Your Ref: OWPC21130
Our Ref: AW/352/18/HH
Please ask for:
Amber Willard

16th January 2019

Removal of shrubbery (15' high x 20' deep) at front of property and erection of boundary wall to replace (Retrospective)
36 Gossamer Lane Aldwick

FRONT ELEVATION

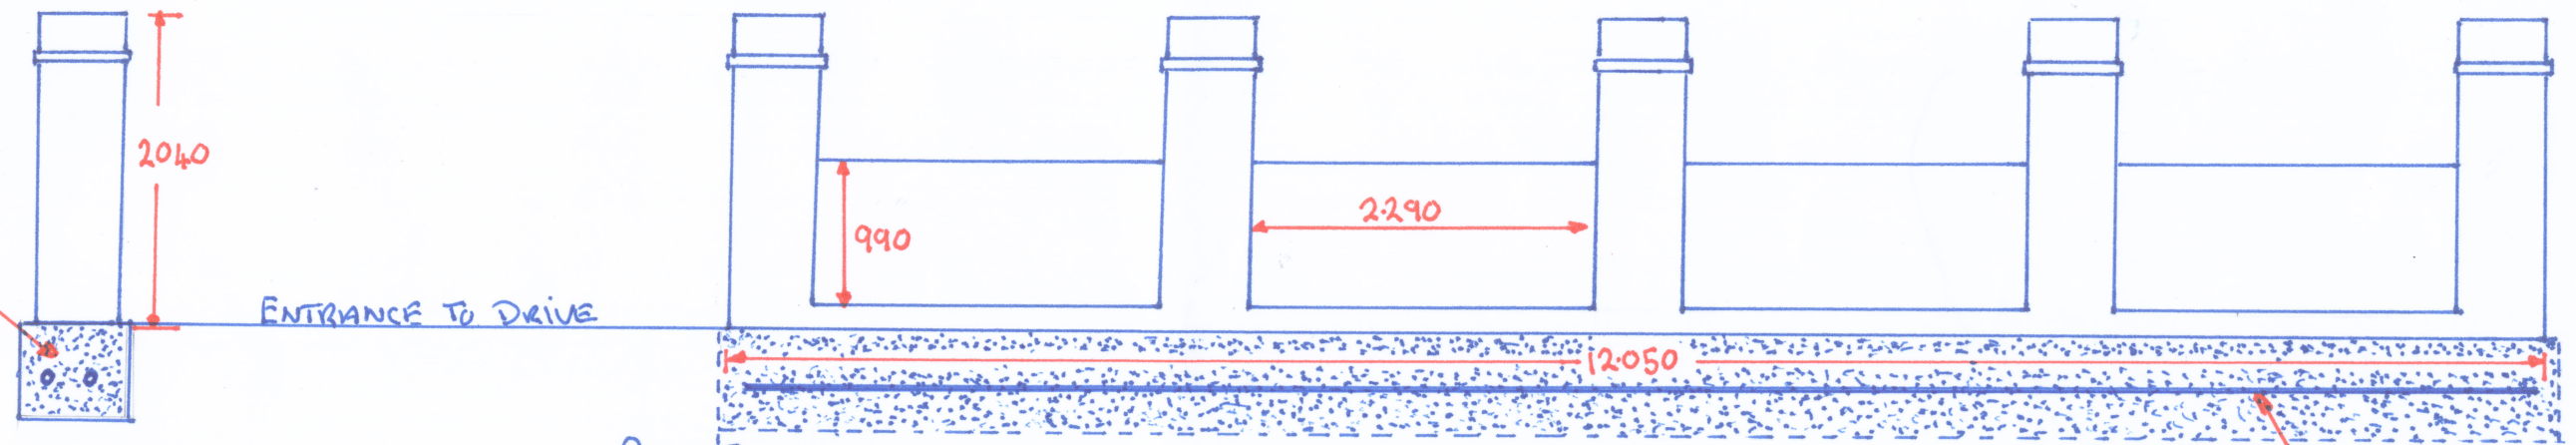
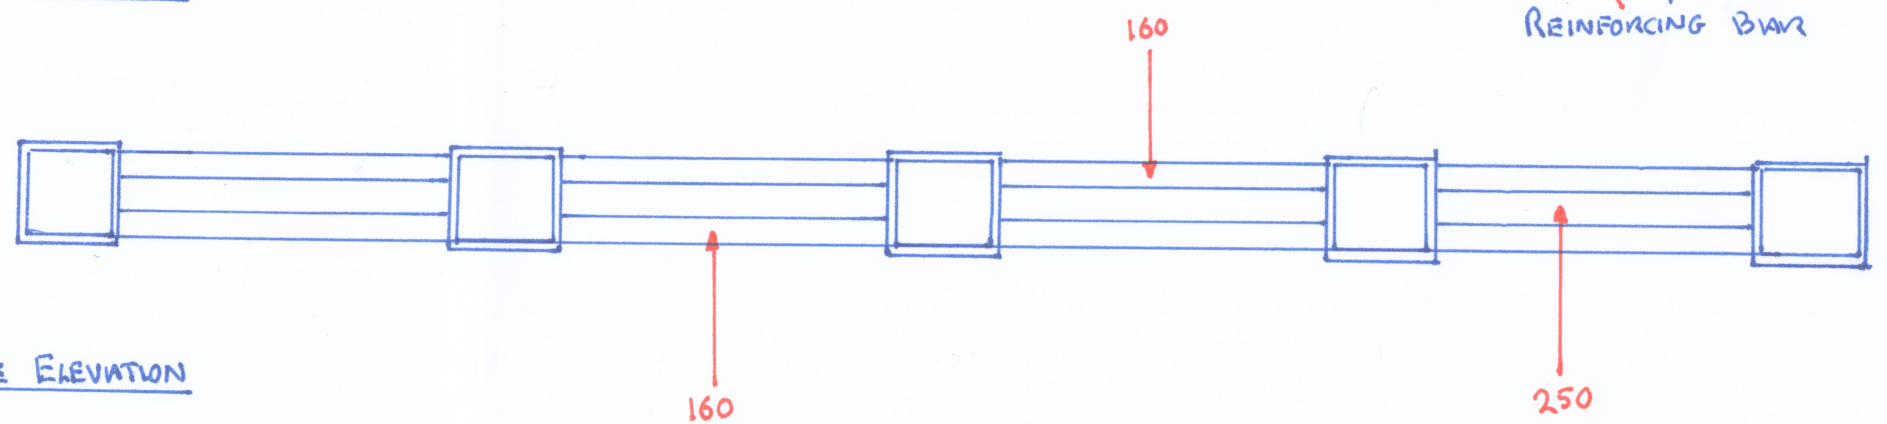
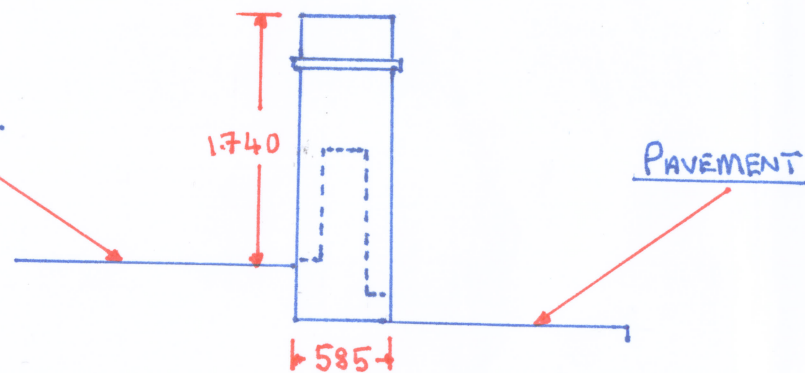
Members strongly opposed the application on the grounds that the proposed alteration does not sympathetically relate to and is not visually integrated with the existing building in siting, massing, design, form, scale and materials because the alteration is not visually subservient to the main building and does not provide a high standard of amenity; because the proposed alteration has an adverse overshadowing, overlooking overbearing effect on neighbouring properties, and because the alteration compromises the established spatial character and pattern of the place. Members also considered that the proposed alteration does not contribute to the overall street scene is in conflict with the established front boundaries of the area and existing walls trees and hedges should be preserved. Therefore Members agreed that the proposed alteration is in direct conflict with Policy DDM4 (a); (b);(c) and (e) of the Arun Local Plan 2011-2031an with the Parish Design Statement Page 7 (no 7) and Page 44 (No 9)
